Comments on the Applicant's D1 Submissions

This document sets out the comments by Cambridgeshire County Council (**CCC**) on the Applicant's Deadline 1 (**D1**) submissions. The table below provides the relevant paragraph or other references used in the submissions.

Drawing Title
Indicative Construction Access and Compounds
Sheet 2 of 5

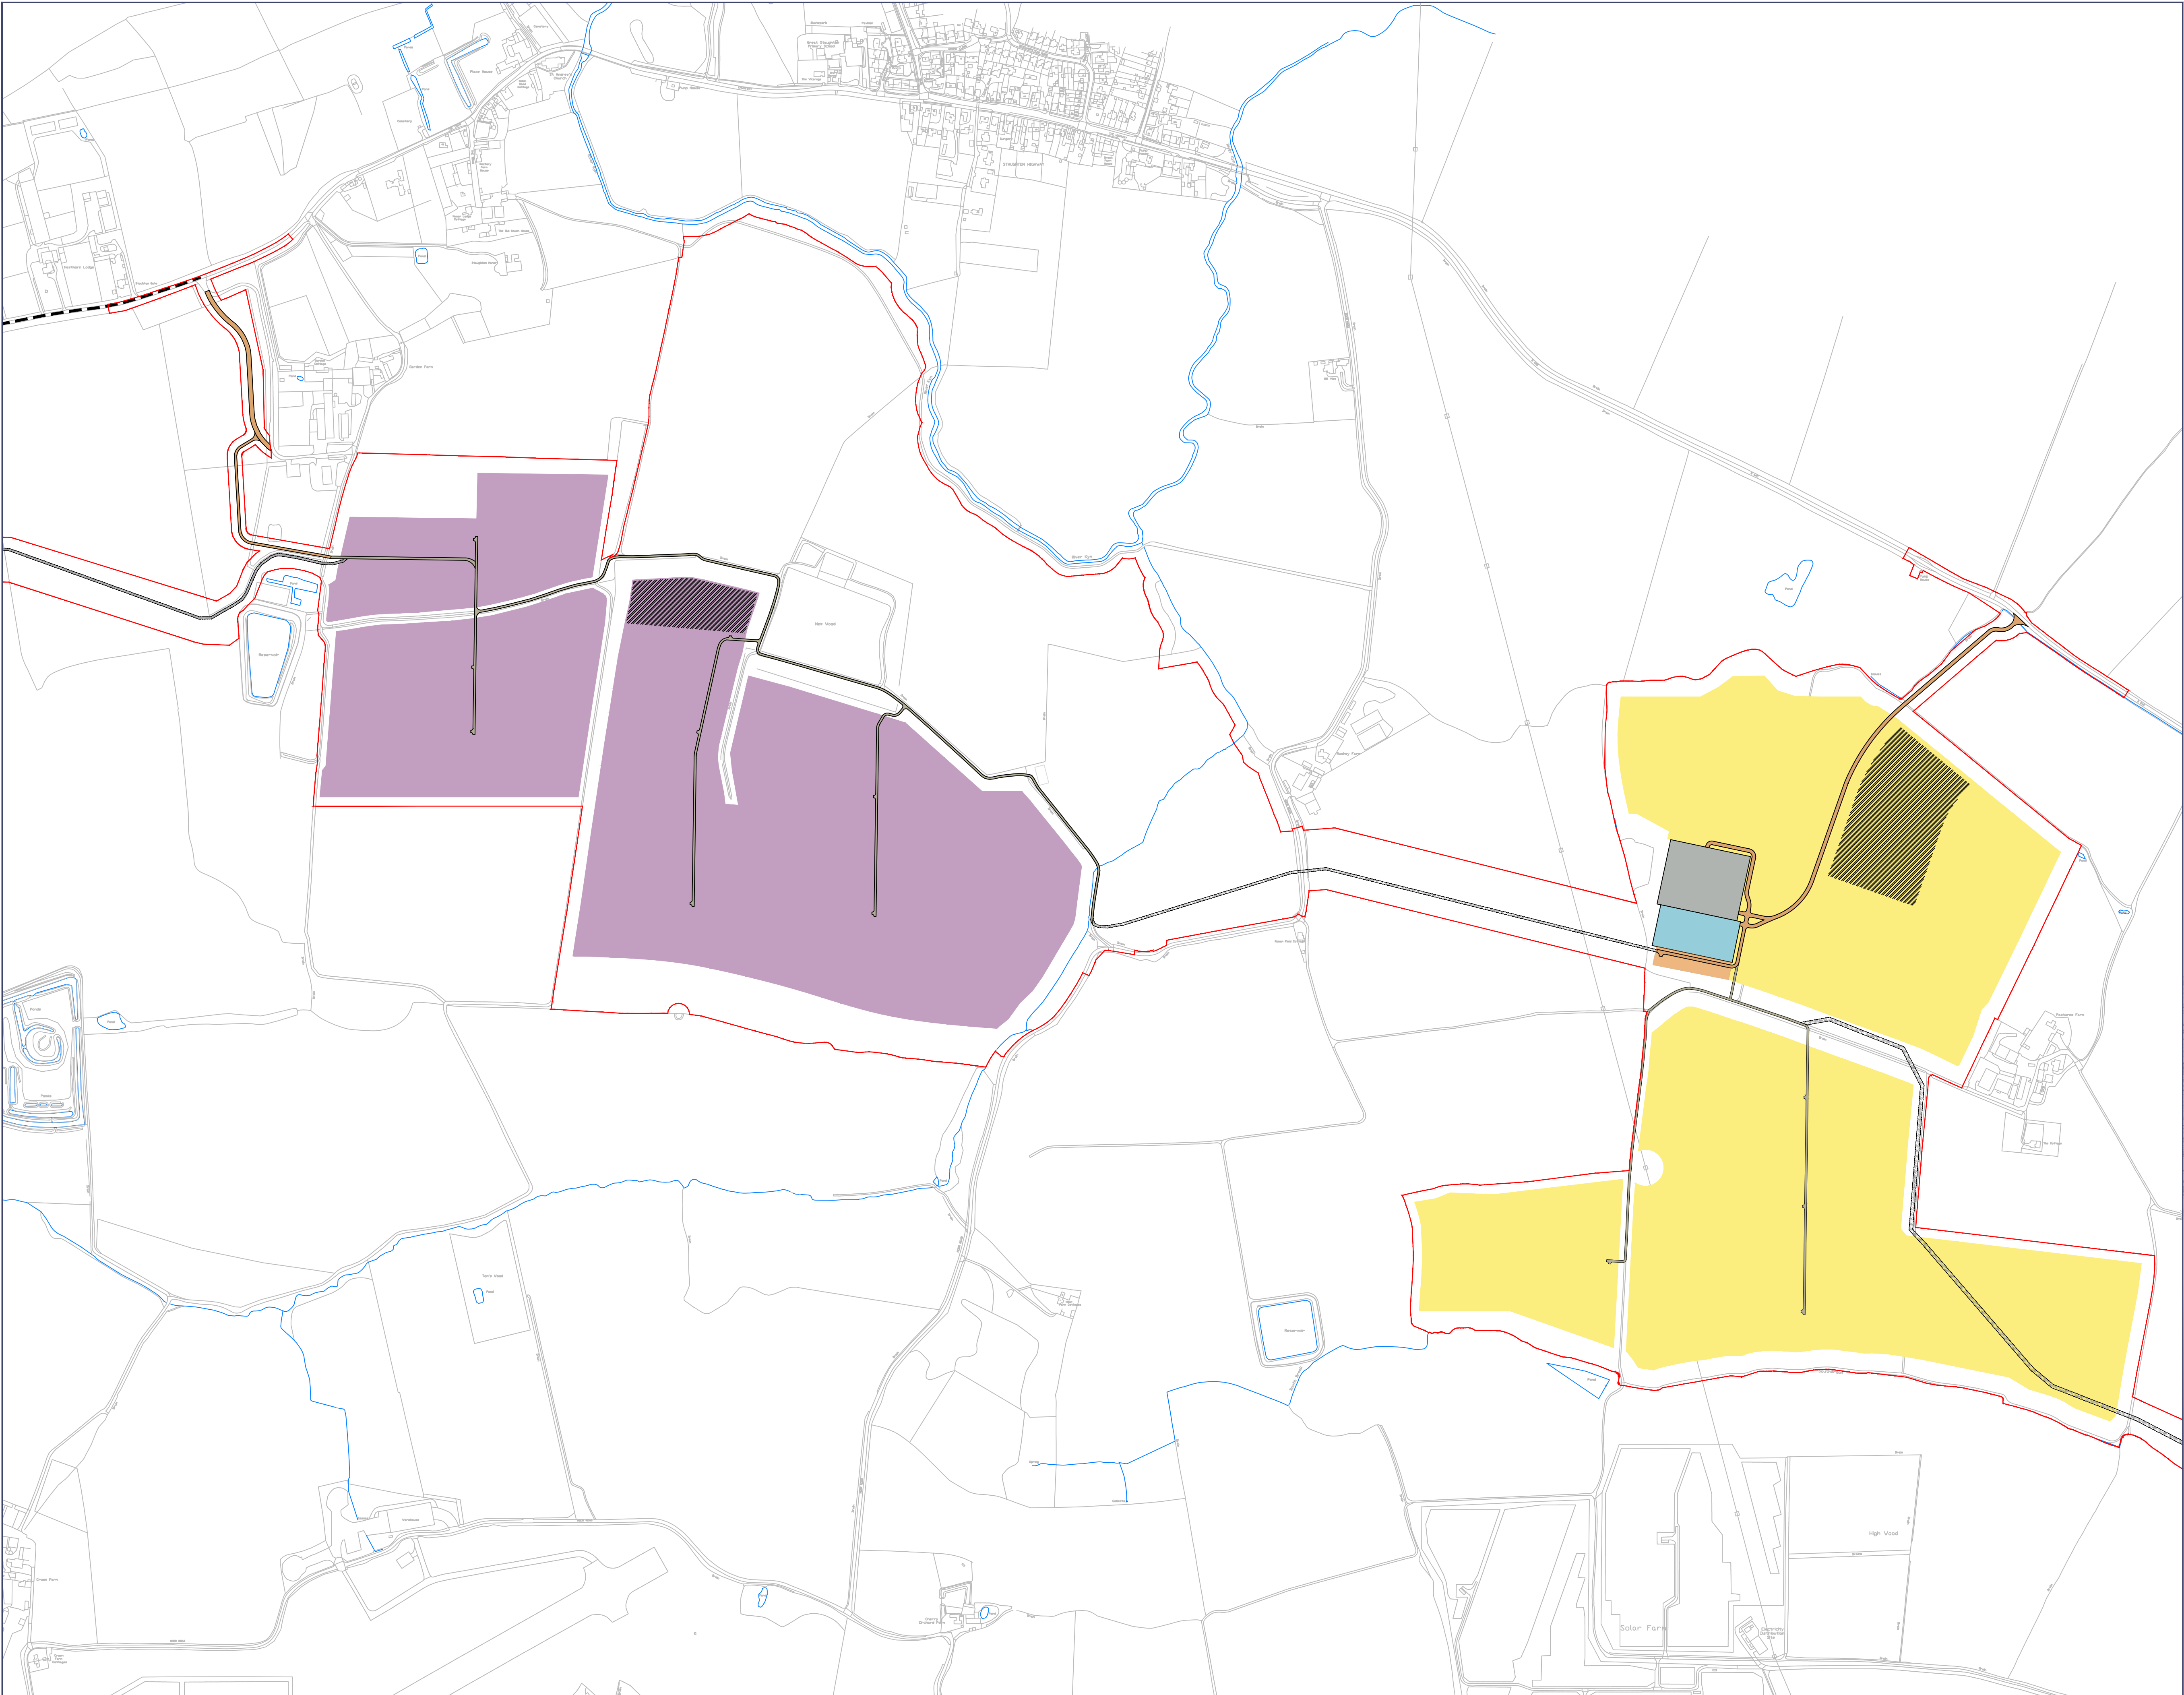
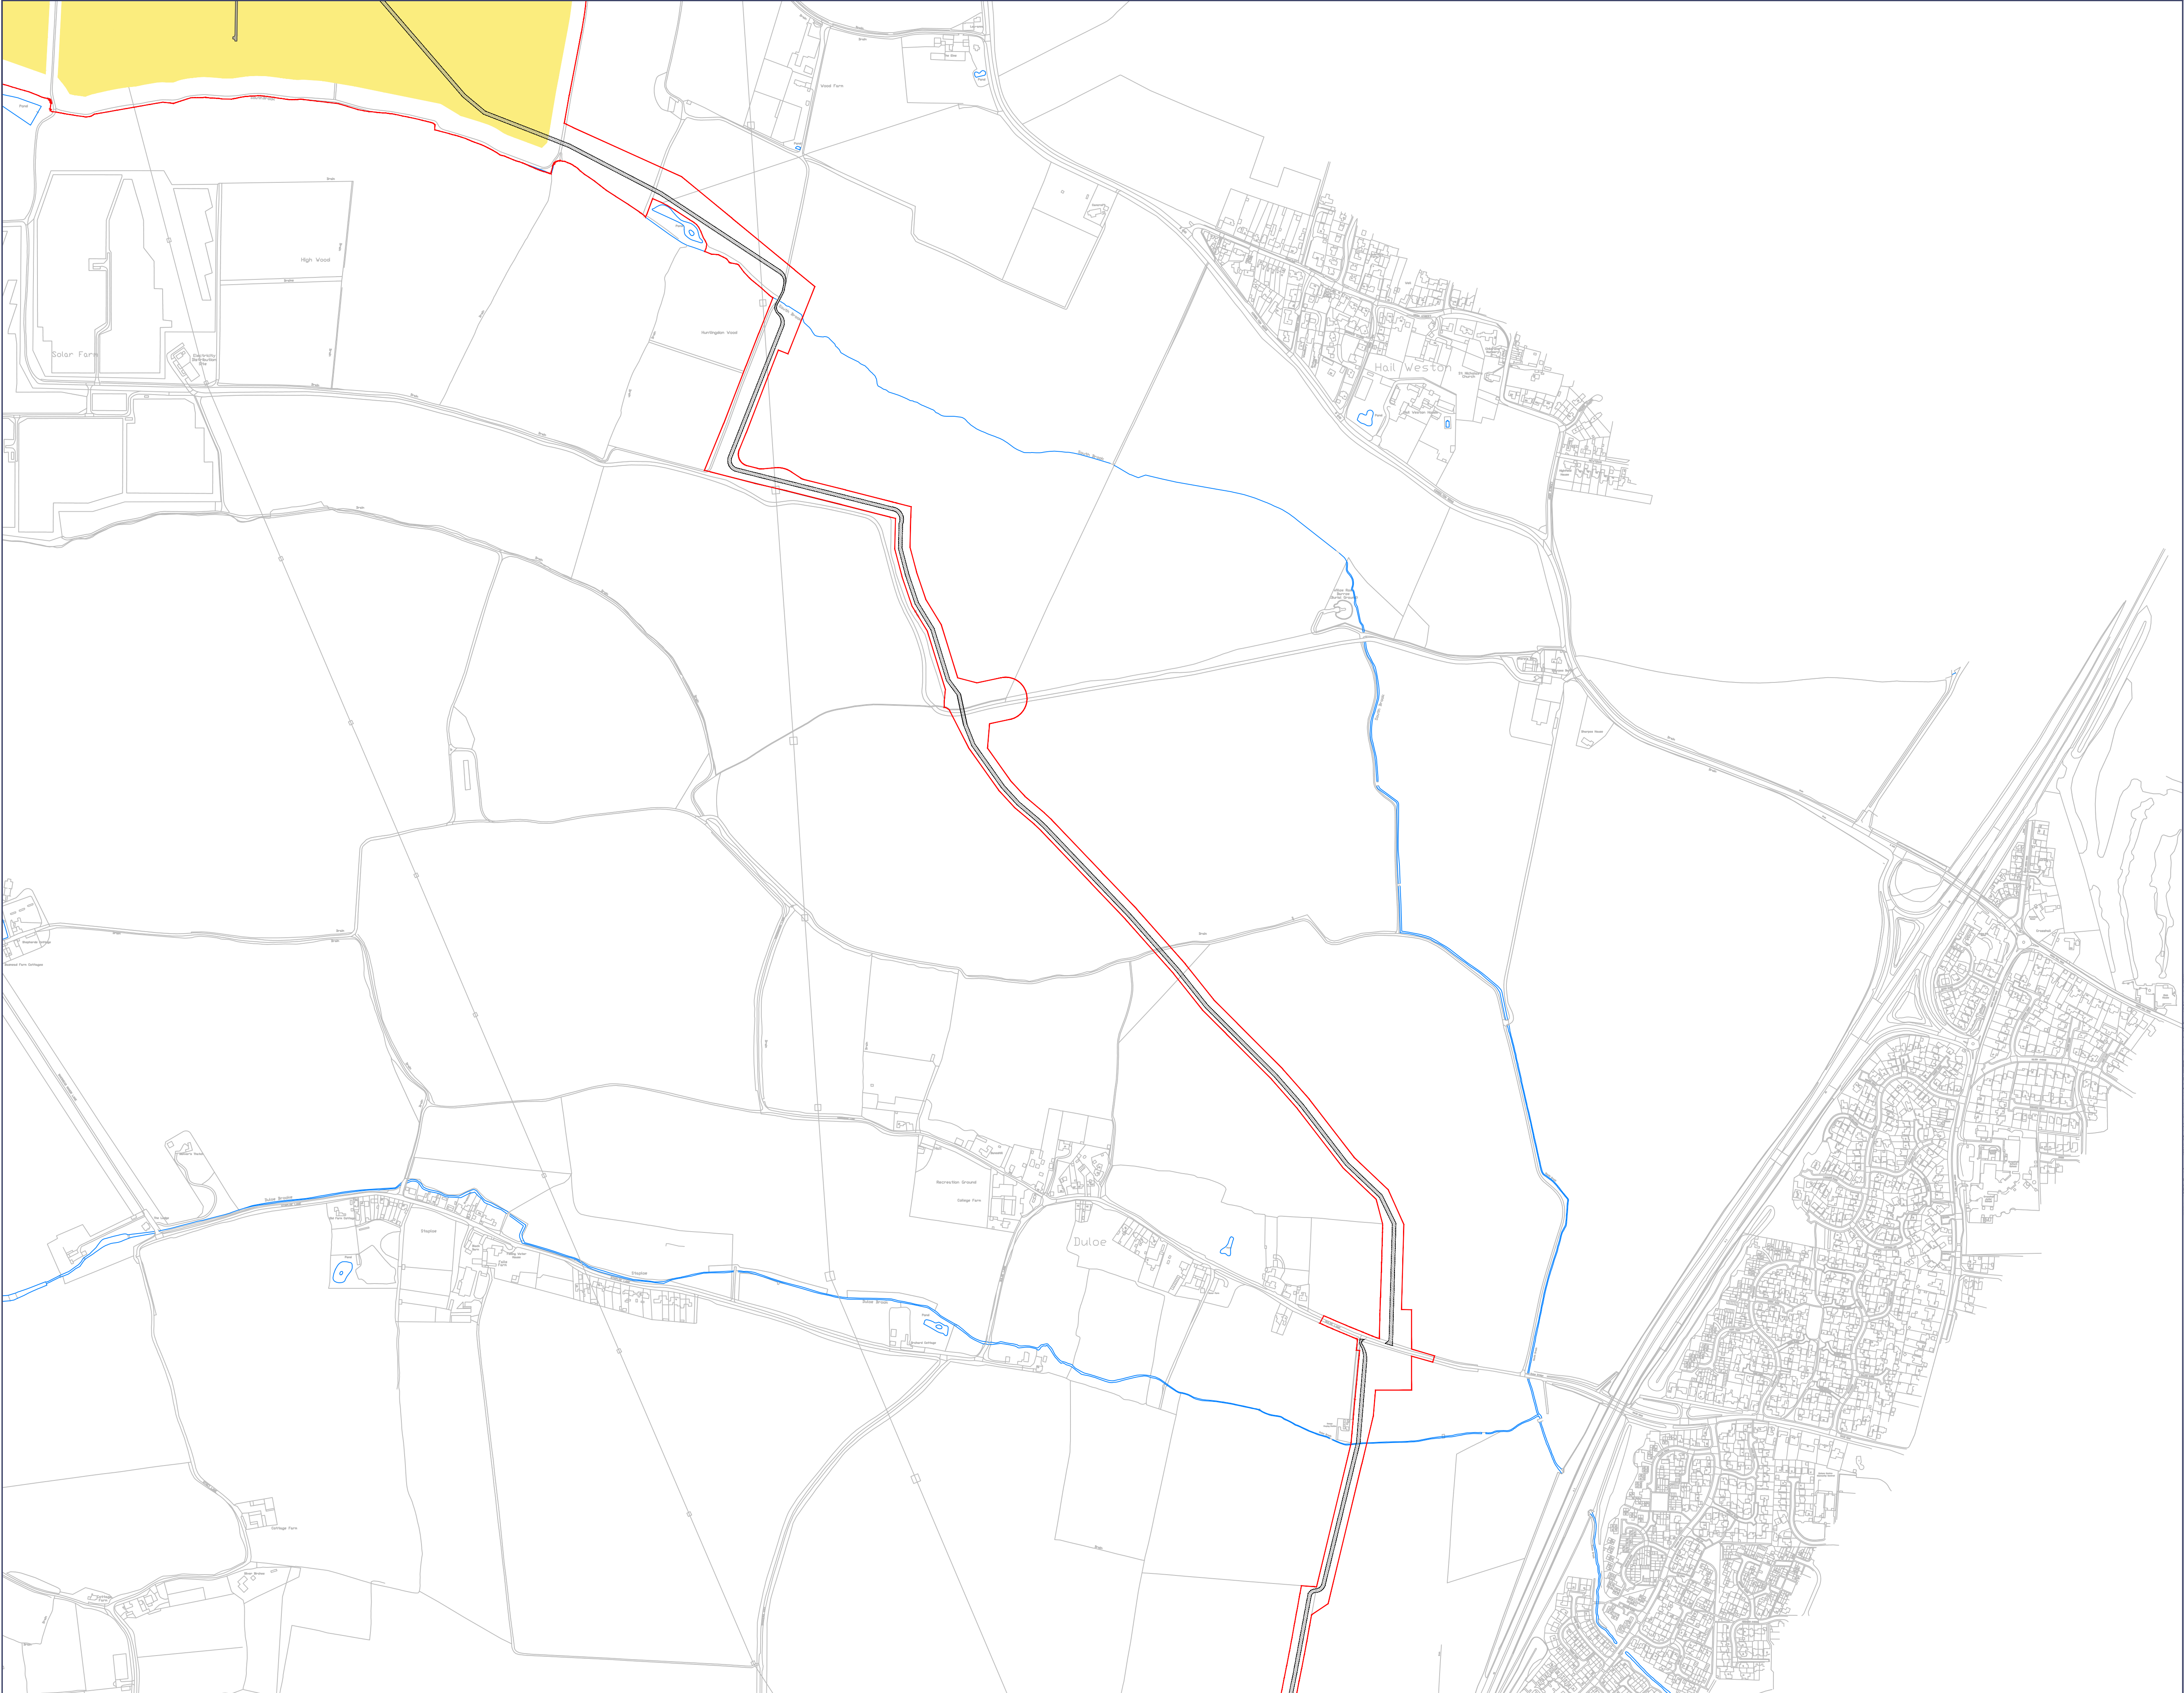
7.1.1	Each access should have a non-granular surface for a reasonable distance from the road edge where, if required, cleaning stations may be located.
Access drawing comments.	SA14 and SA15 Construction only accesses / crossing point	Visibility requirement has not been met as indicated before, the recorded speeds are above those required to assess by Manual for Streets requirements i.e. above 37mph. It is noted, however, that the speed surveys were carried out remote from the location of this crossing. Therefore, either further speed surveys will be required, or temporary traffic regulation orders would be required to reduce the speeds of vehicles with appropriate warning signage.

With regards to the access width, it is noted that two vehicles are unable to pass at the location of the crossing with a 4m width. The crossing should be of sufficient width to allow two-way simultaneous movements at locations adjacent to the highway. While it is indicated within the CTMP that vehicles will be controlled so that none should meet, this safeguard should be built in as standard to mitigate for such instances.

A width of 7.3m for a distance of 20m from the road edge should be sufficient.

<p>The council queries why 4m radii have been applied to the design. As no vehicles are proposed to use Moore Road, the inclusion of these would only seem to allow manoeuvres. The council requests that the applicant removes these to ensure straight across movements only. Moore Road has limited width to accommodate construction traffic for the project.</p>
	<p>SA13 operational access</p>	<p>Whilst this is an existing access, the council has not seen any information relating to the existing use and or proposed use, so requests clarity on whether there will be additional volume.</p> <p>The proposed splays are also indicated but no speed measurements have been undertaken in this location to ascertain if they are adequate.</p> <p>The tracking has been undertaken with a 10m rigid vehicle – the council requests clarity as to whether this is the largest vehicle likely to use the access, with details provided of the frequency to ensure the single width nature is acceptable.</p> <p>The council also notes that it is not a balanced junction regarding radii, and requests further information as to whether any vehicles using the access will only enter and leave from the North.</p>

<p>SA16 Main construction access</p>	<p>In the tracking plan provided, the vehicles appear to clash when manoeuvring in the location below. The council requests that the applicant provides tracking or alters the geometry so that this does not occur.</p> 
	<p>SA12 Zantra access</p>	<p>The council notes that this access has already got approval for HGV use and there is no damage evident on Google Earth.</p>
